**DELEGATED DECISION FOR APPLICATION FOR CERTIFICATE OF
LAWFUL DEVELOPMENT**

Reference no.: 2023/CL/92496/W

Site: 1-2, Broadfields, Slaithwaite, Huddersfield, HD7
5UD

Description: Certificate of lawfulness for proposed erection of
rear extension and garden room/gym

Proposed Ground Floor
1 : 100

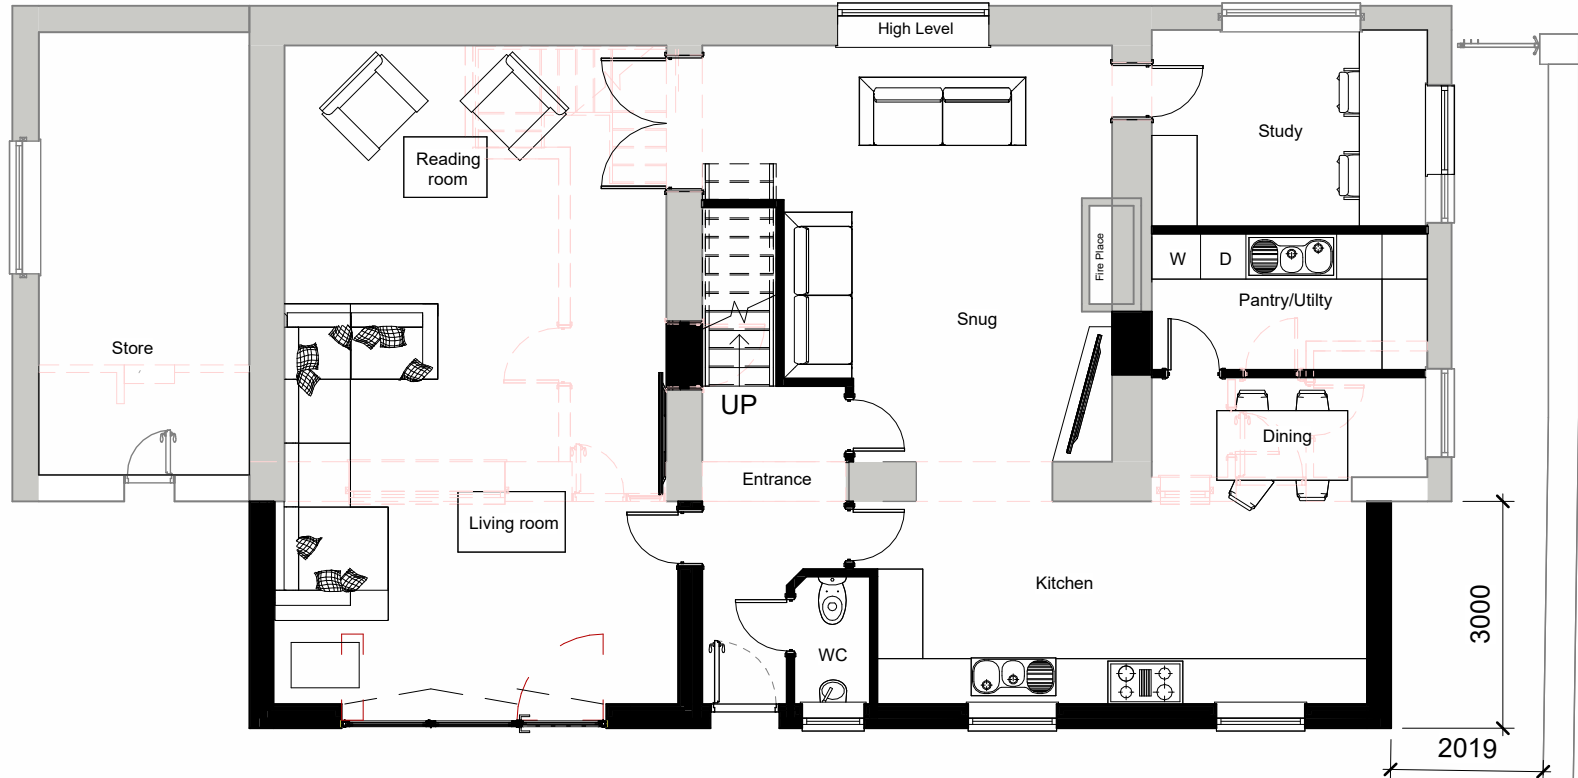
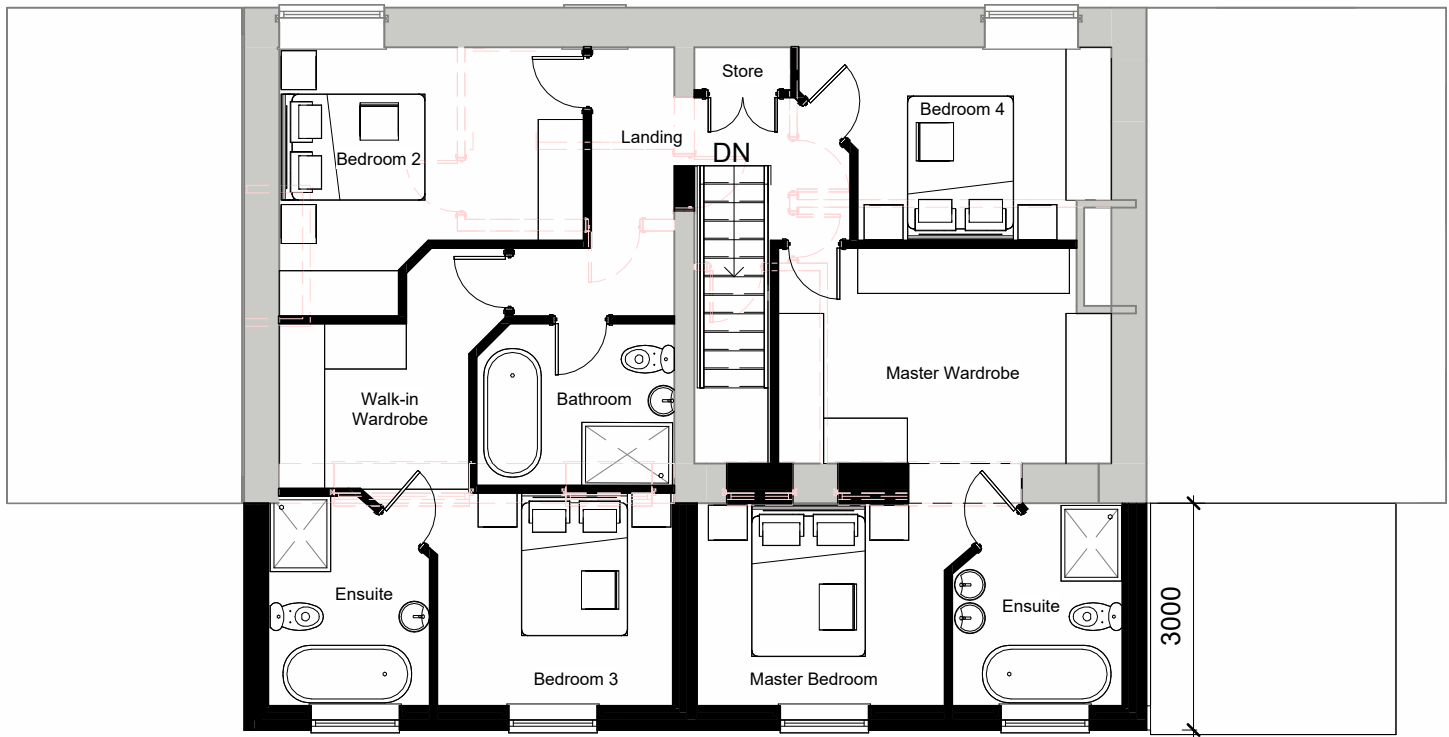
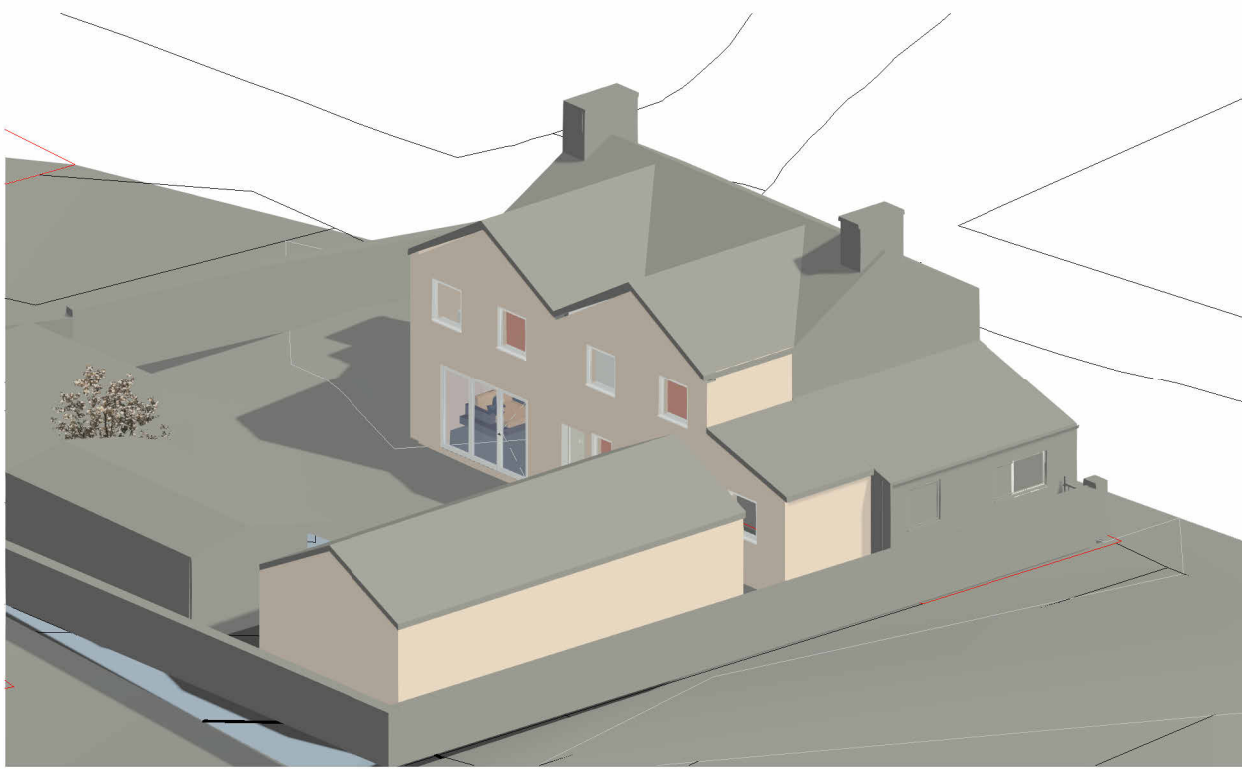
- 11.1 The basis of the applicants submission is grounded on the proposal benefitting from a general planning permission granted by virtue of article 3(1) of the Town and Country Planning (General Permitted Development) (England) Order 2015 (as amended) [“GPDO”]. To succeed on these grounds would mean the proposal complying with the limitations as set out in paragraphs A.1 and E.1 of Schedule 2, Part 1, Classes A & E of the GPDO.
- 11.2 The initial submission includes plans indicating a proposed single storey rear enlargement projecting from the east elevation of the existing single storey south part of the building adjoining the south

elevation of the proposed two storey enlargement. Historic imagery held by the Council indicated this proposal would have adjoined an existing enlargement to the original dwellinghouse which extended beyond a side elevation of the original dwellinghouse. As this would adjoin the proposed two storey enlargement which extends along the entire width of the original dwellinghouse the inclusion of the single storey element would result in the enlargements to the property falling outside the limitation under paragraph (j) and (ja) of Class A.

- 11.3 The initial submission also indicated the northern single storey enlargement to be located within 2 metres of the northern boundary. In these circumstances the Courts (*Hilton, R v SoS [2016] EWHC 1861*) have judged that development as a whole must fall within the scope of permitted development and thus the eaves height of the two-storey part must be considered irrespective of whether that part of the development is more than two metres from the boundary. As such this would fall outside the limitation in paragraph (i) of Class A.

- 11.5 In response to the above matters being questioned, the agent has revised the plan 2796 (100)02 by omitting the single storey south enlargement, setting in the single storey north enlargement from the north boundary and reducing the size of the outbuilding with some justification why the building is required. Revised plan 2796 (100)02 rev A is the amended proposed plan.

Proposed South Elevation
1 : 100

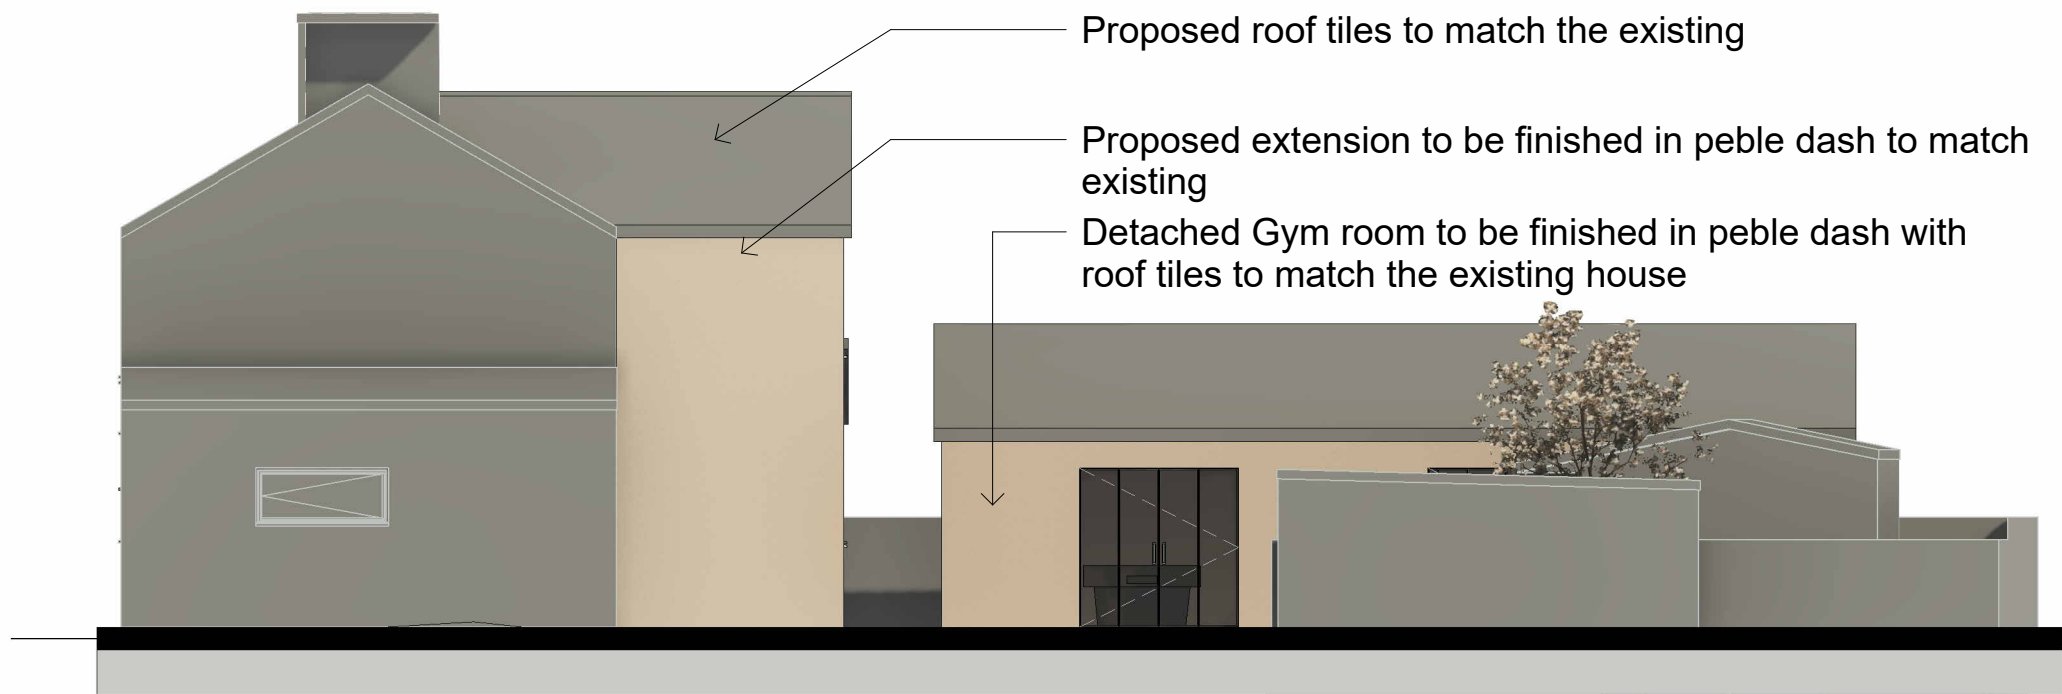
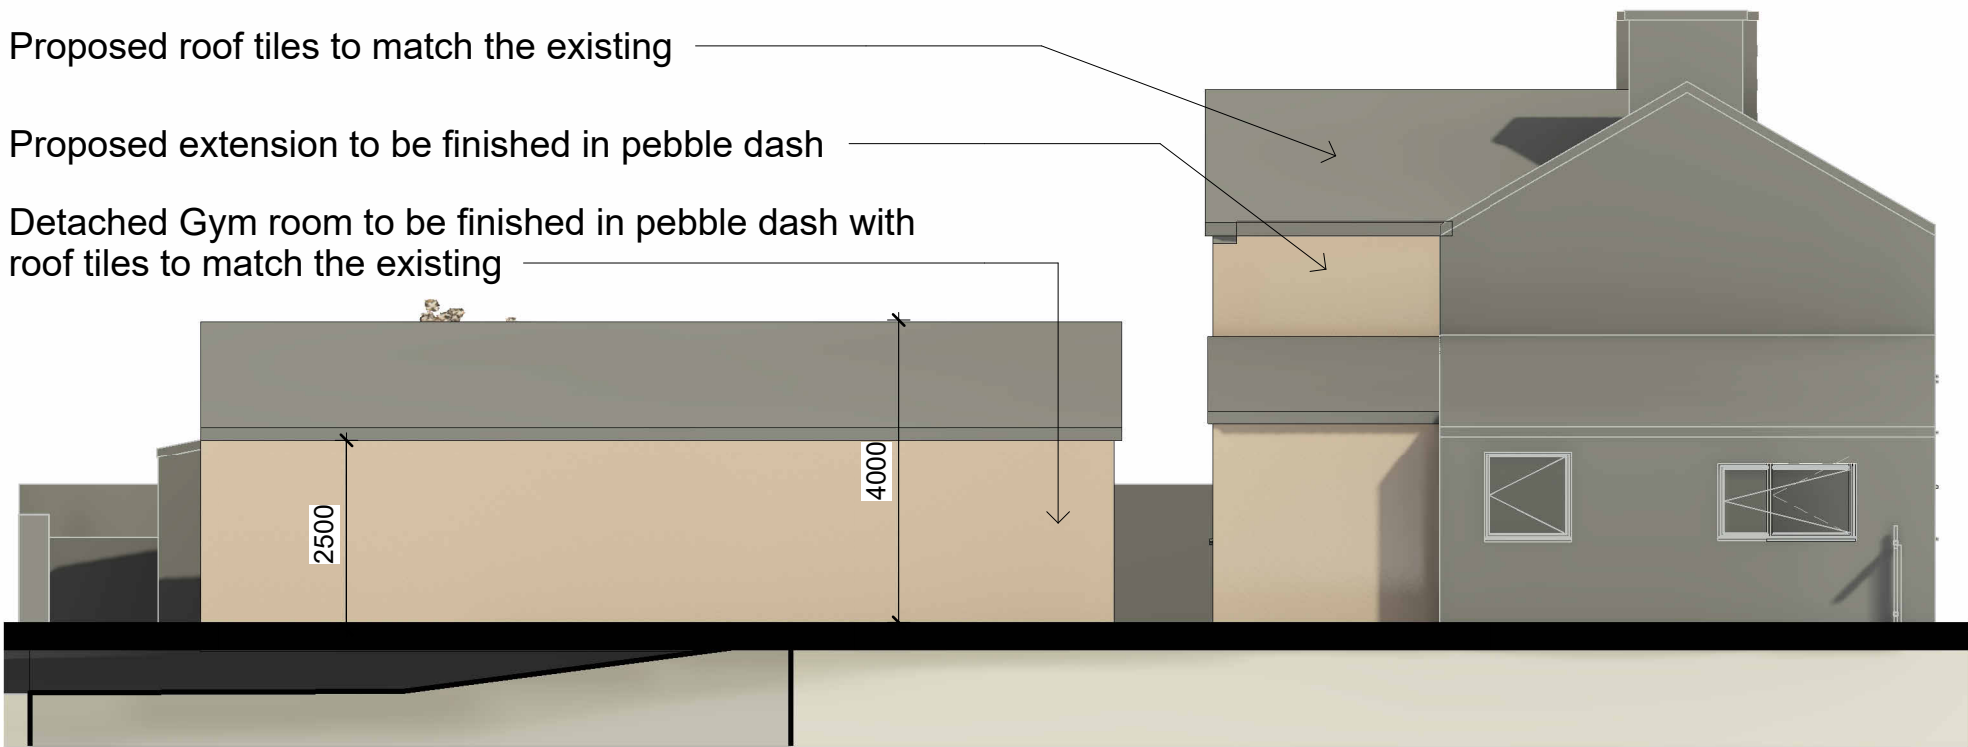
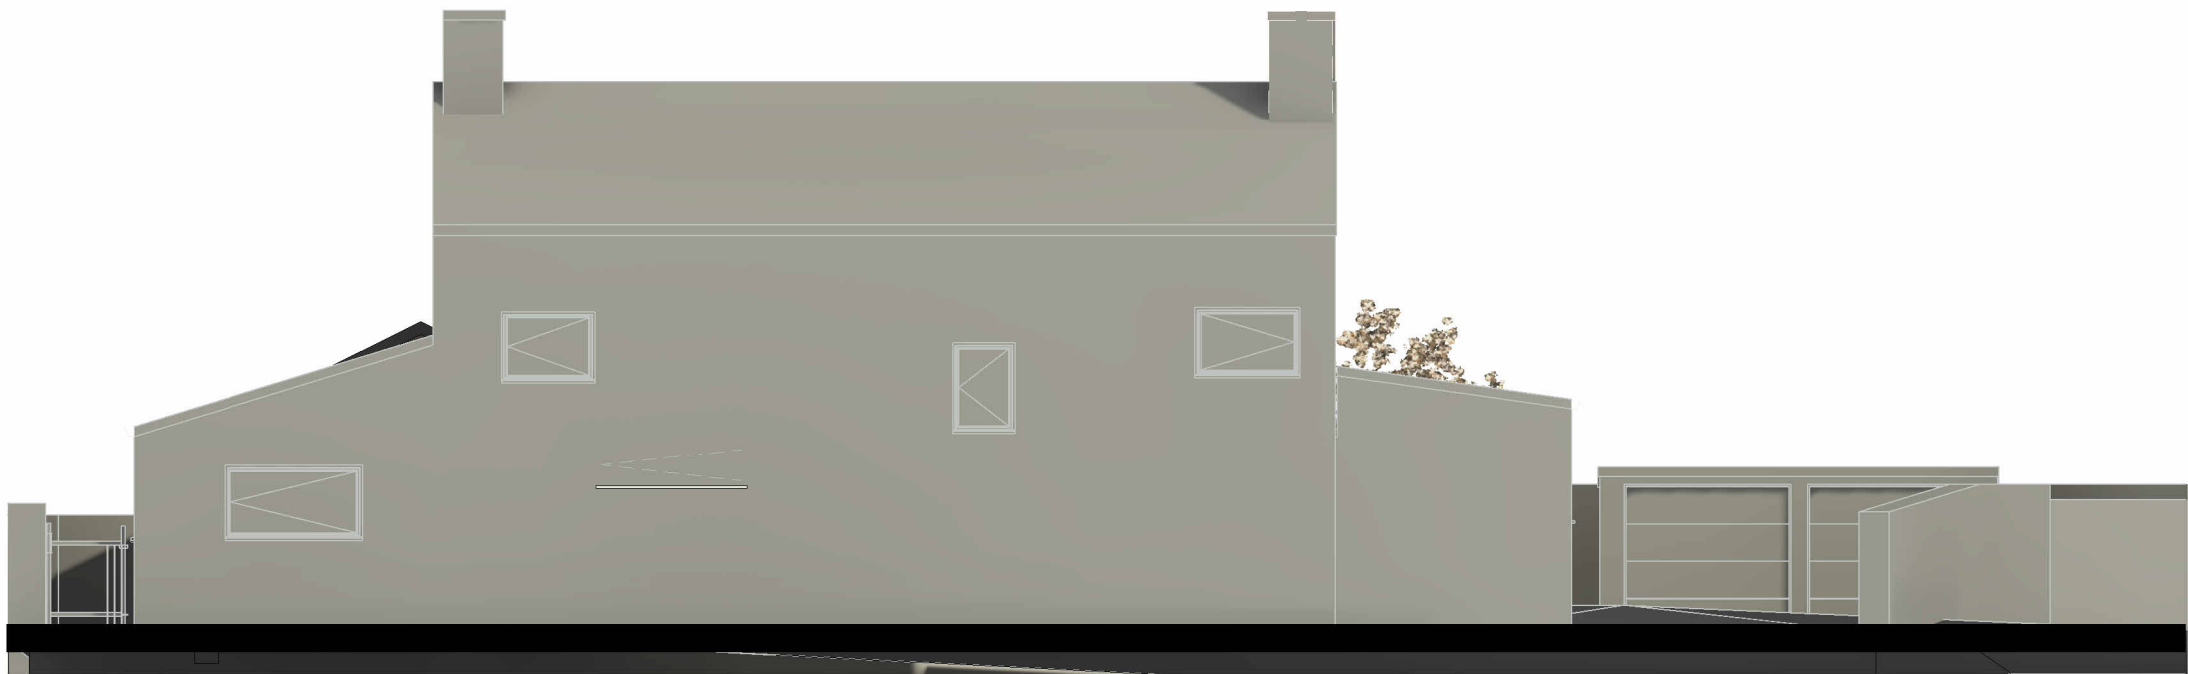
- 11.4 The size of the proposed gym was also questioned in terms of Class E development and that the use must genuinely be incidental to the enjoyment of the dwellinghouse in order to benefit from Class E.

- 12.5 The initially proposed gym was unjustifiably large for it to be regarded as reasonably incidental to the dwellinghouse and as such the agent elected to reduced the size and include a games room with the gym. The agent also reasons that the owner is a former professional sportman who continues to enjoy sports and keeping fit. In such circumstance the proposed games room and gym can be considered subordinate and genuinely required for the purposes the building will be put to and therefore incidental. The other outbuilding are clearly not fit for the same purpose given there condition and size.
